**REPORT ON THE JOINT WORLD HERITAGE CENTRE / ICOMOS
ADVISORY MISSION TO
STONEHENGE, AVEBURY AND ASSOCIATED SITES**

27-30 OCTOBER 2015

**Chris Barker, Civil Engineer, ICOMOS
Nathan Schlanger, Archaeologist, ICOMOS
Marie-Noël Tournoux, Project Officer Europe and North America Unit, World Heritage
Centre**

PROPOSED BORED TUNNEL - (WORK No. 1F)

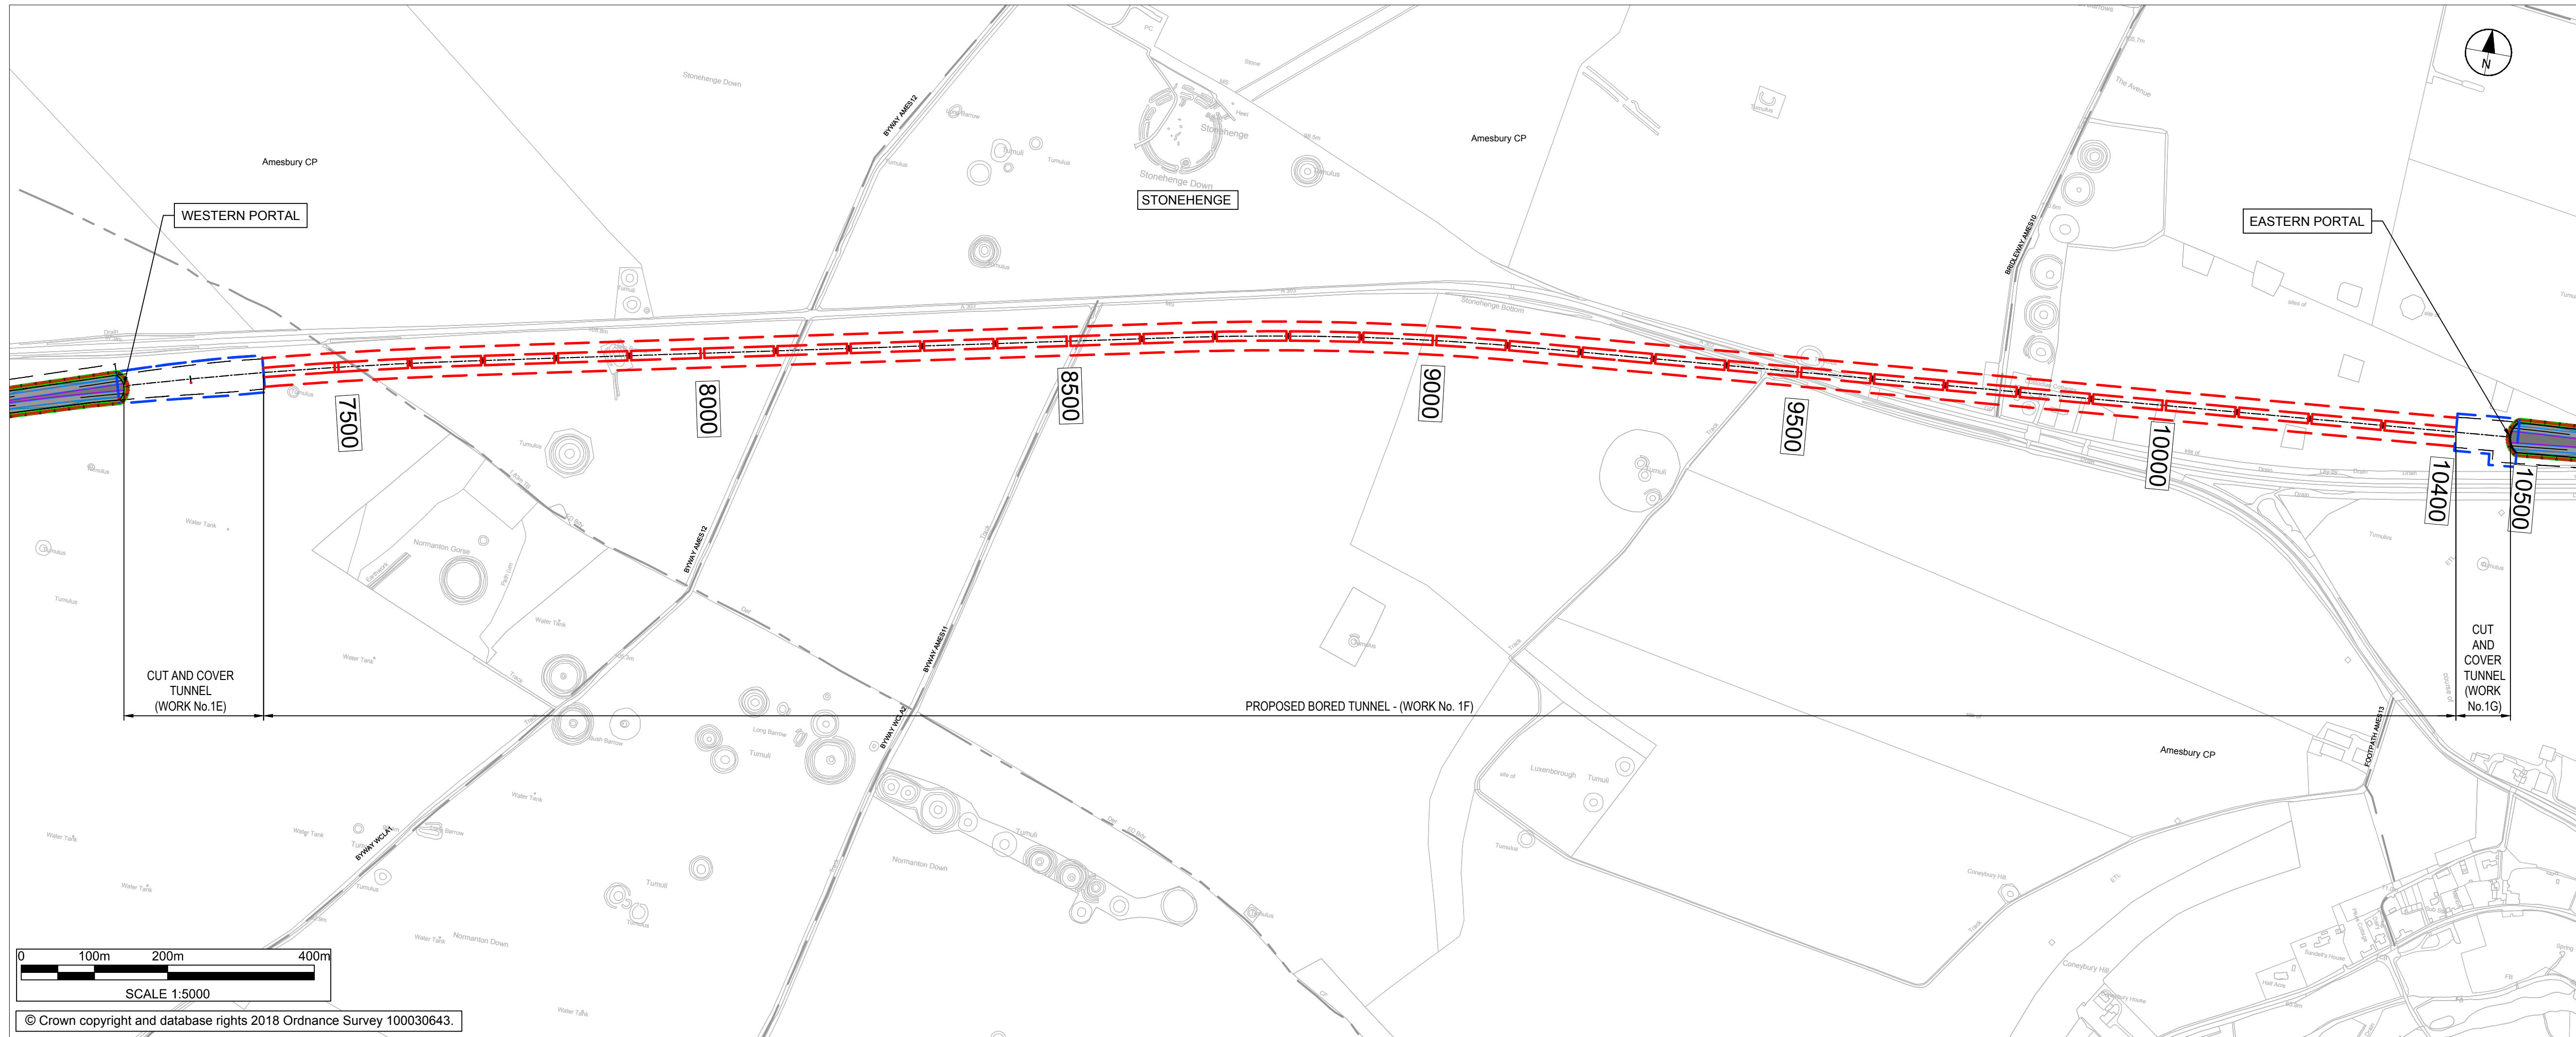
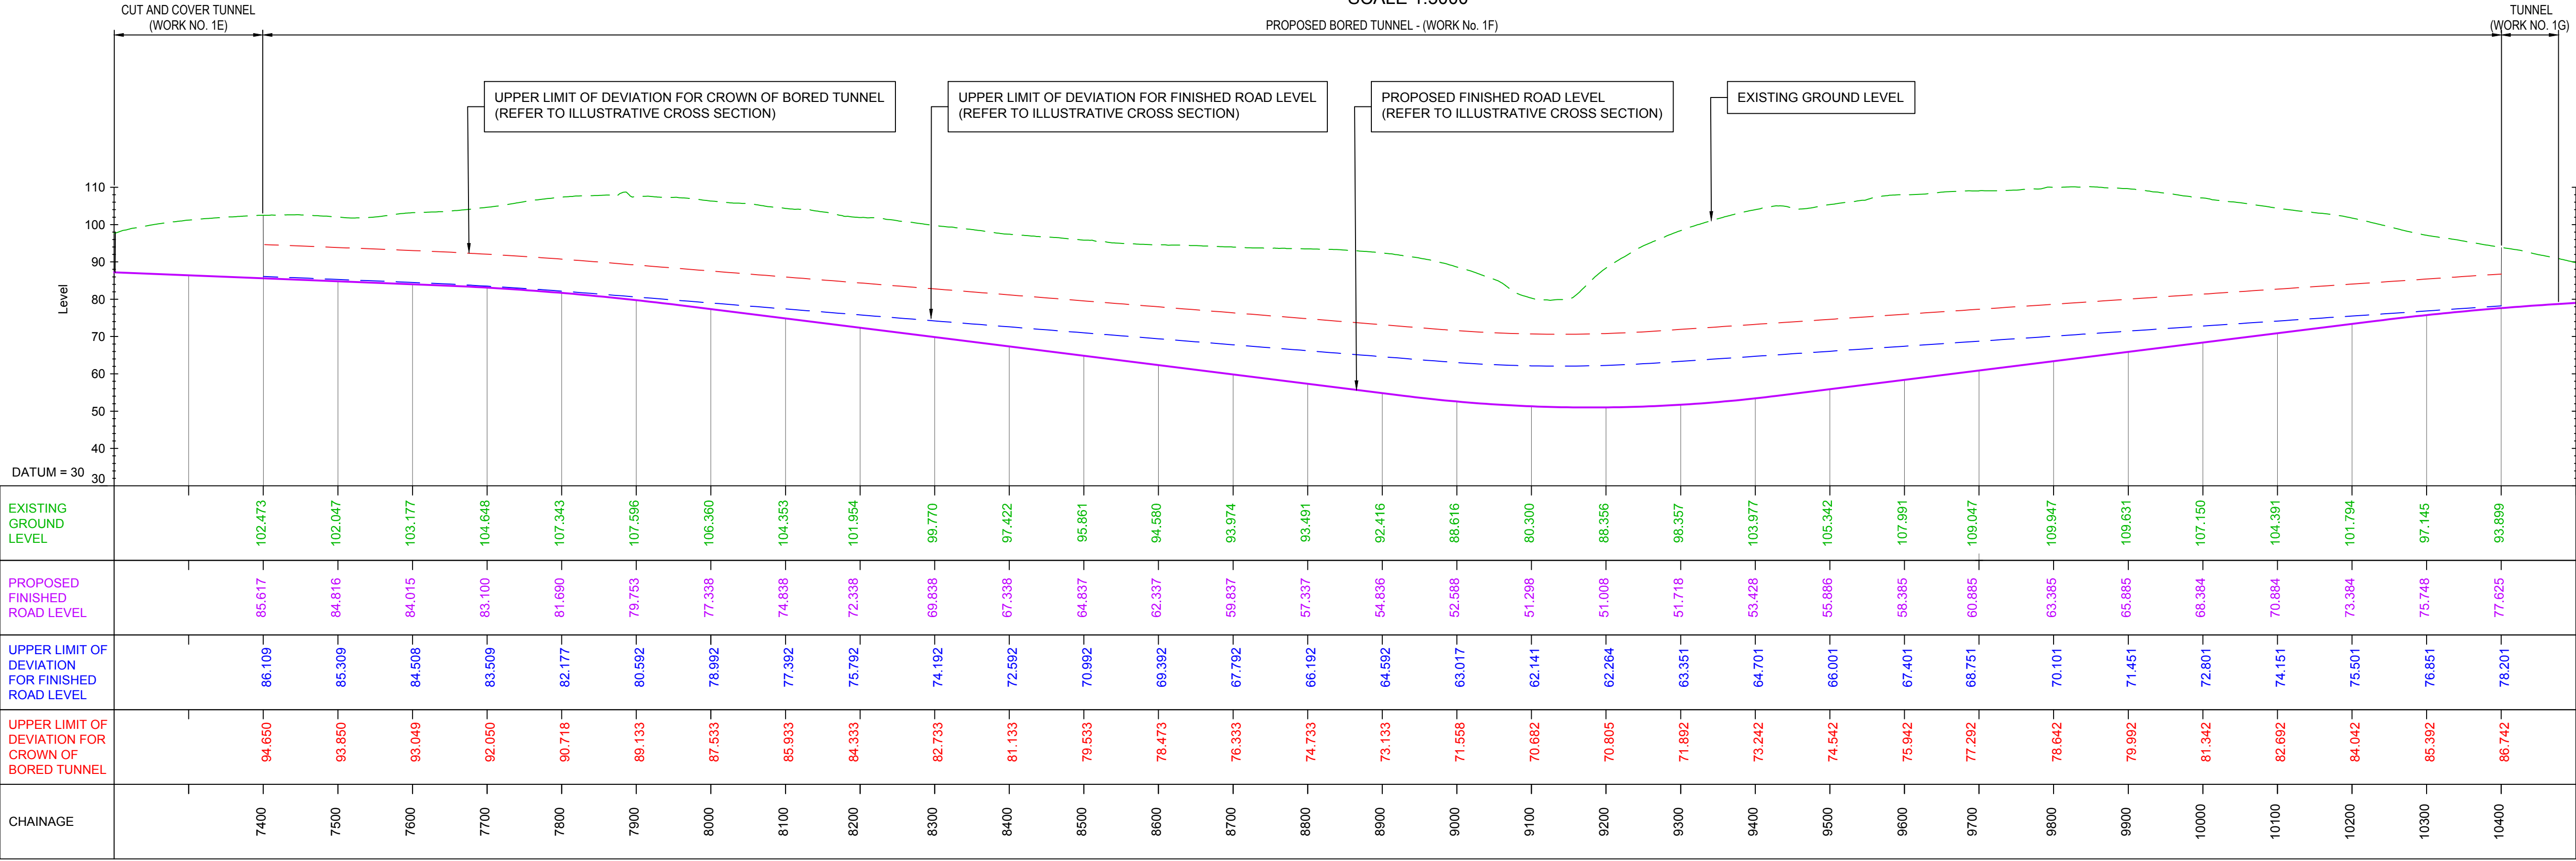
One of the proposed locations of the western portal (A1 on figure 2, 3) was presented to the mission in detail during the on-site visits, and seems to present a number of advantages. This A1 location seems to be in a visually non-intrusive position in the landscape and avoids known archaeological features. The path of the A303 westwards will furthermore release the Winterbourne Stoke barrow group and render it accessible for visitors and research. This is highly beneficial for parts of the site and some of its attributes of OUV provided that the same standards and heritage procedures apply to the west of the A360. Indeed, the Stonehenge tunnel project should also consider the redesign and development of areas outside of the World Heritage site such as the Countess Roundabout and linking the smaller towns and villages.

However, the 1 km long approach road and the cuttings/embankments and entry/exit ramps to the west of the portal within the property have the potential to adversely impact on some attributes of OUV in terms of integrity of the overall Stonehenge cultural landscape and the visual links between monuments. This will need to be considered as proposals and HIAs are developed for option selection (as set out below). These latter aspects of the scheme, in particular, will require rigorous investigation, evaluation, iterative design and assessment if they are to protect the attributes of OUV within the World Heritage site and the surrounding Archaeological Priority Area (APA).

It is not clear why the option of placing the eastern portal (currently at proposed point 'E') further to the east of the King Barrow ridges (point 'F') has so far not been considered (or is not being considered, except in the case of 4.5 km tunnel). Is it because of the costs incurred by lengthening the tunnel by approximately 250 metres? Because placing the tunnel entrance there will mean decommissioning a stretch of the A303 that is already dual carriageway? Or is it, beyond economic or logistical considerations, because some known heritage features (which ones?) might be situated on some other planned eastern portal and could be impacted, or cannot be mitigated?

For all these reasons, it is strongly recommended that new detailed evaluation studies be undertaken to better grasp and carefully consider the issues surrounding the placement and design of the eastern portal of the tunnel scheme as proposed in Snashall & Young.
